Project # 1002068

Project Name: Town of Atrisco Grant Unit 6

DRB Comments

RE: Lots 150 & 151, Town of Atrisco Grant Unit 6

P.O. BOX 44414 RIO RANCHO, N.M. 87174
Phone (505) 896-3050 Fax (505) 891-0244

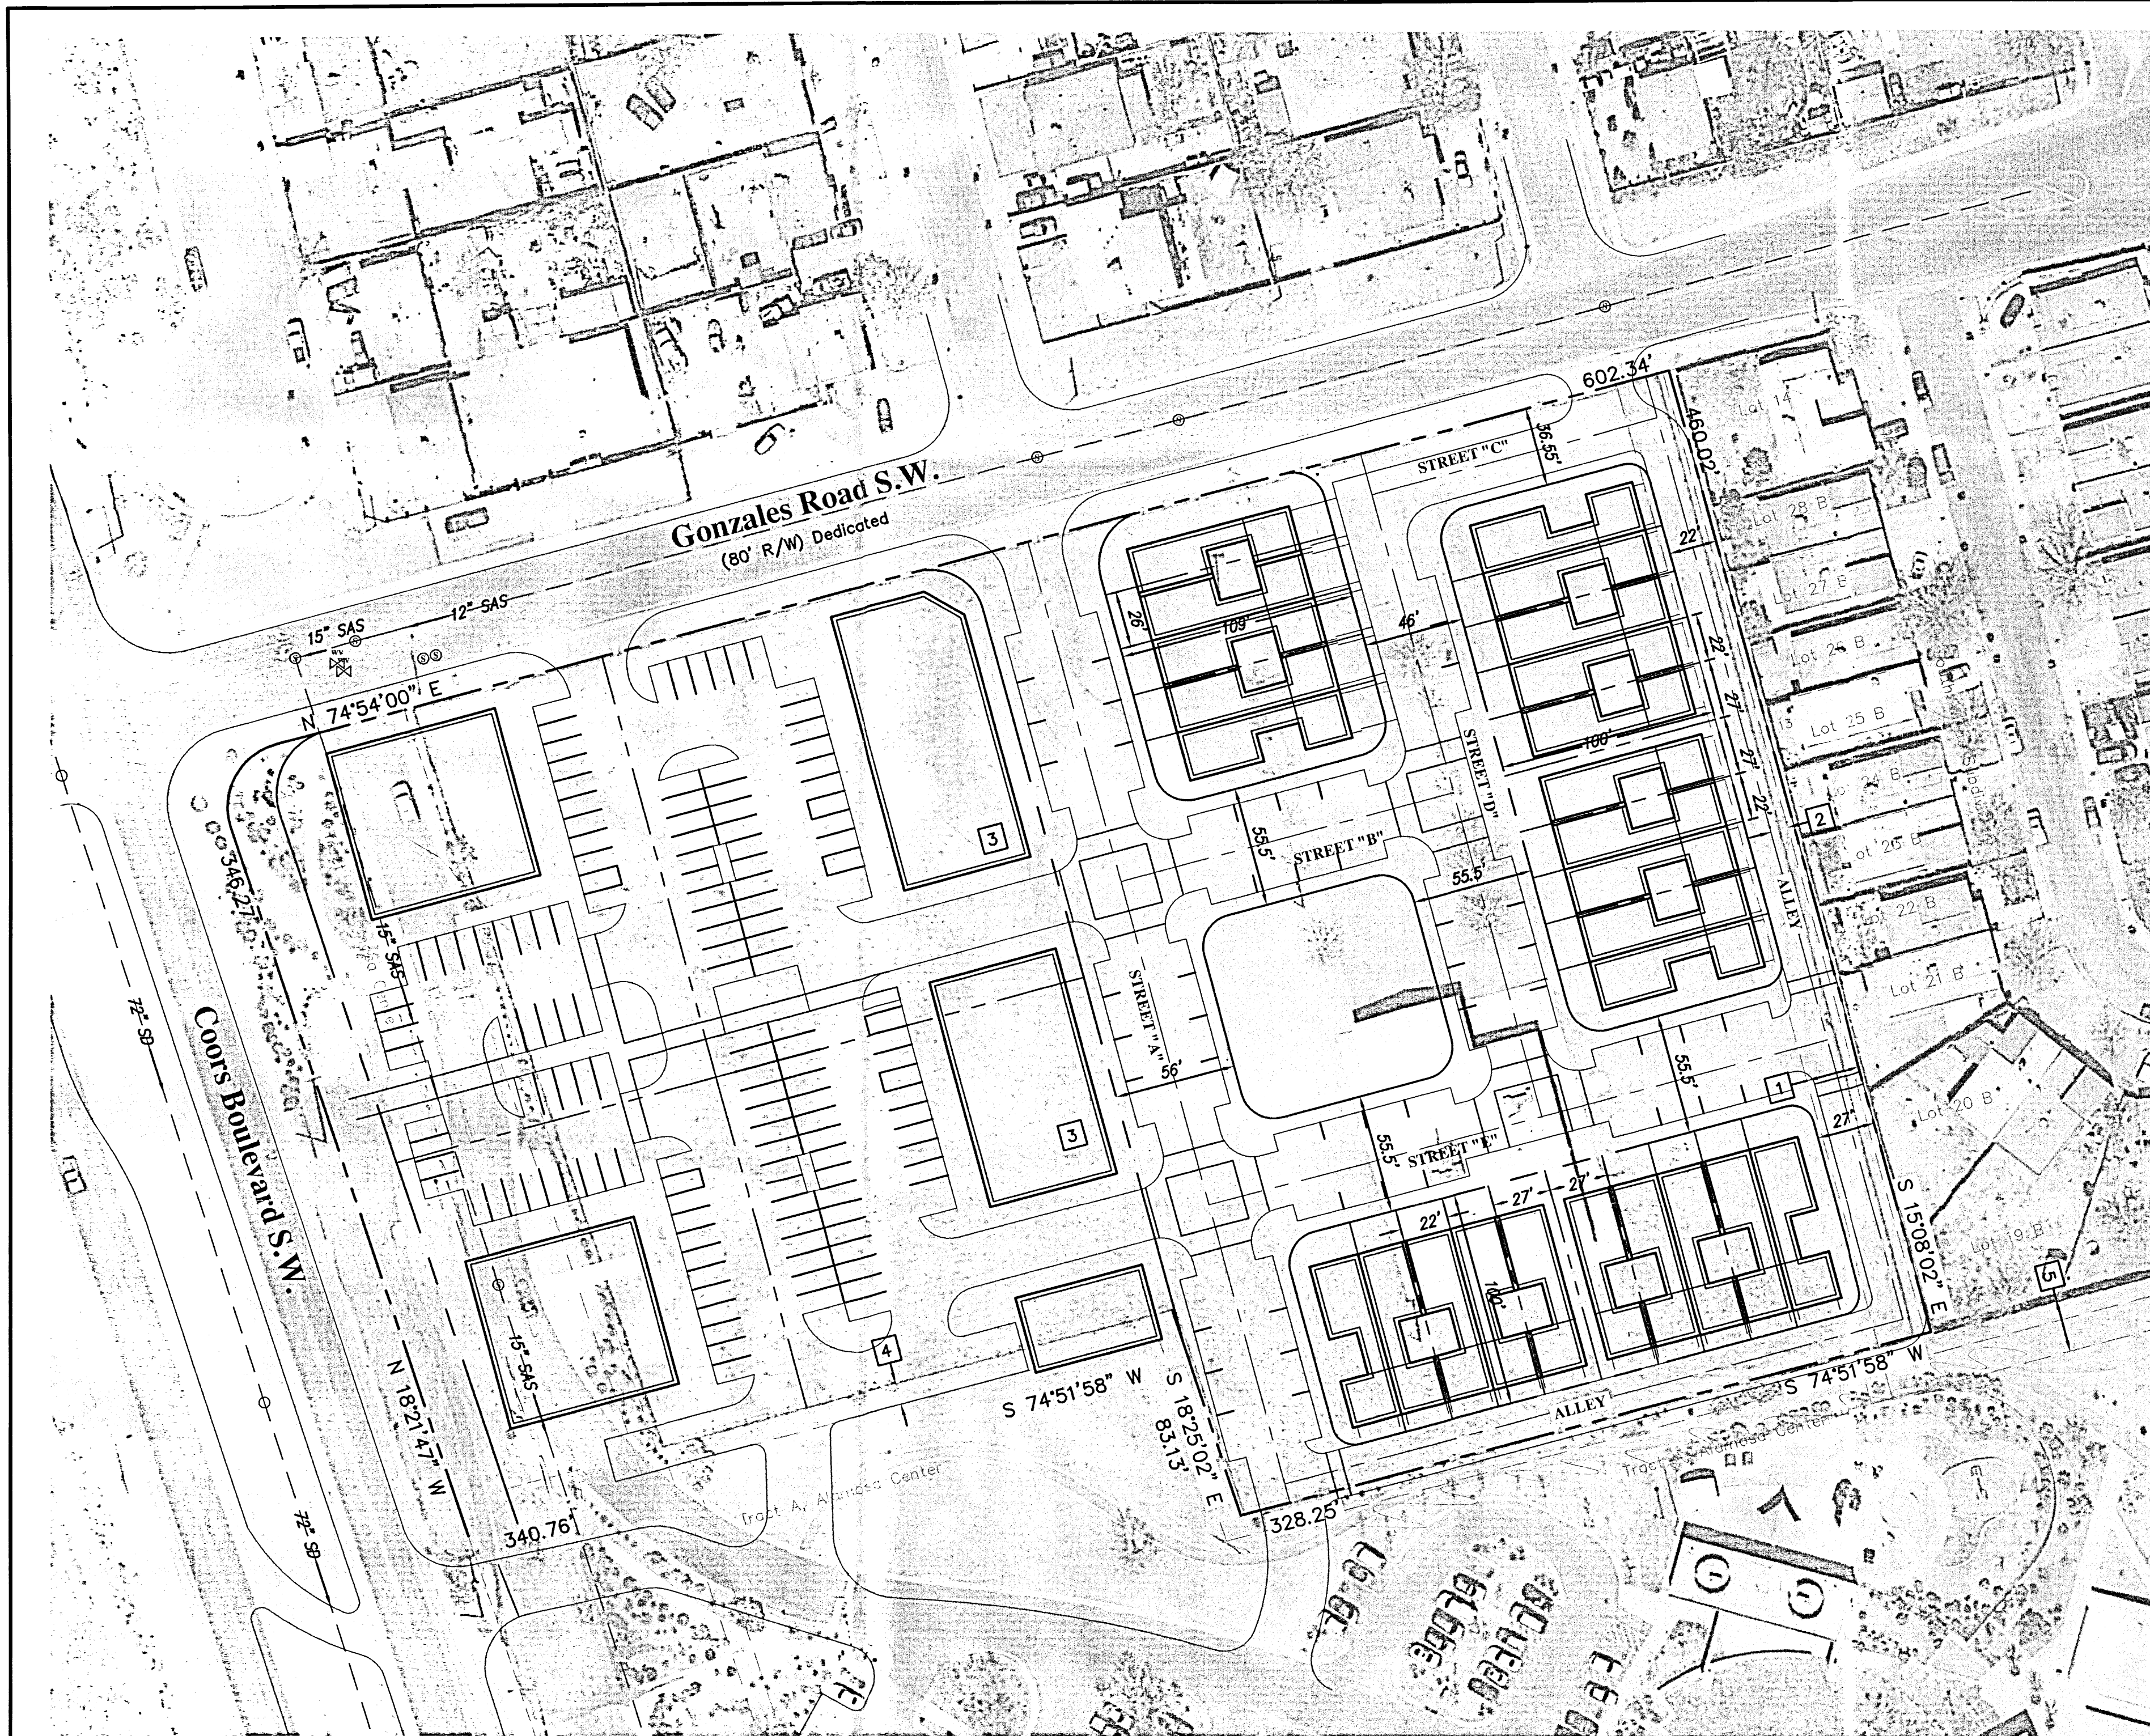
Beneficiaries of the easements proposed for Vacation must be “clearly and completely defined and all agree to the vacation” [§ 14-14-7-2(E)(1) of the Subdivision Ordinance], or else an advertised public hearing would be required.

Franchised utility companies need to sign-off on the plat or acknowledge their approval of the plat in writing. AGIS needs to approve the .dxf file prior to Planning sign-off.

TYPICAL LOT LAYOUT & LANDSCAPE PLAN

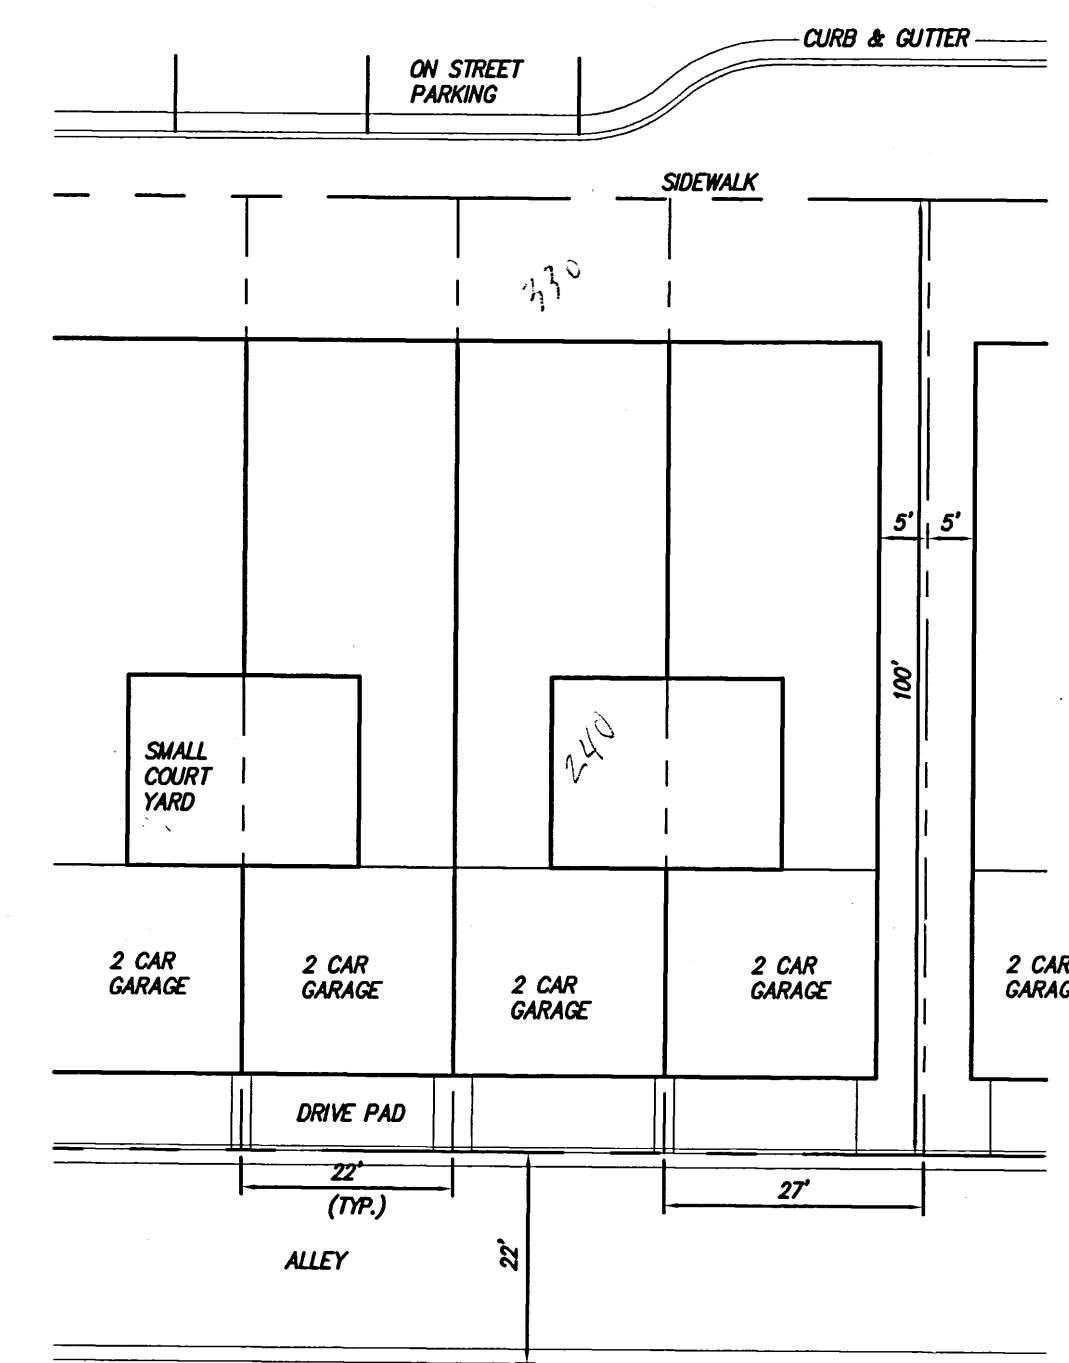
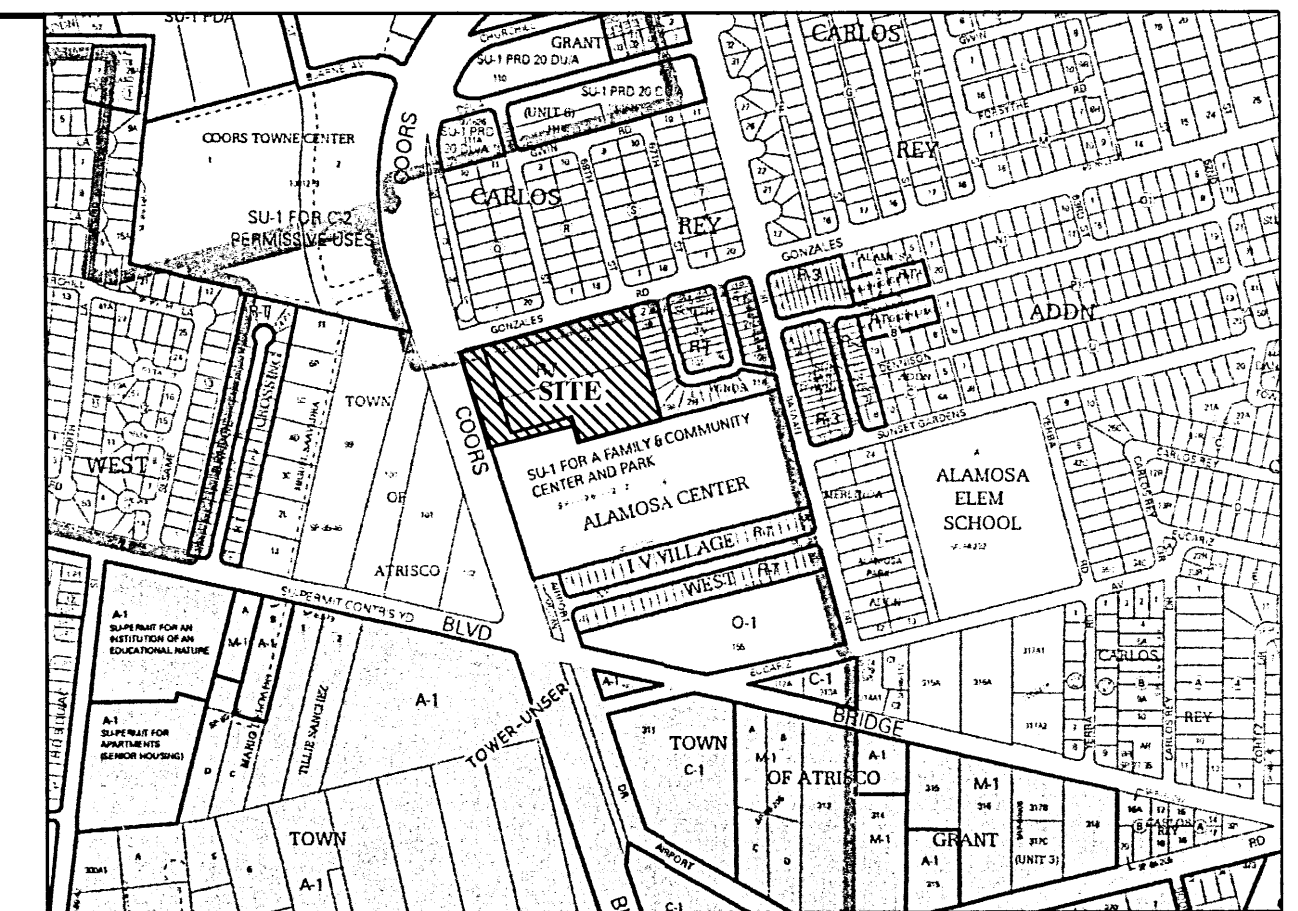
The site is within the Tower/ Unser Sector Development Plan area; RT regulations apply. 'Typical Lot Layout' does not conform with driveway/ rear yard setbacks (20 ft and 15 ft respectively).

Additionally, second story heated space or rear wall with a view of the alley is required if an alley is constructed.
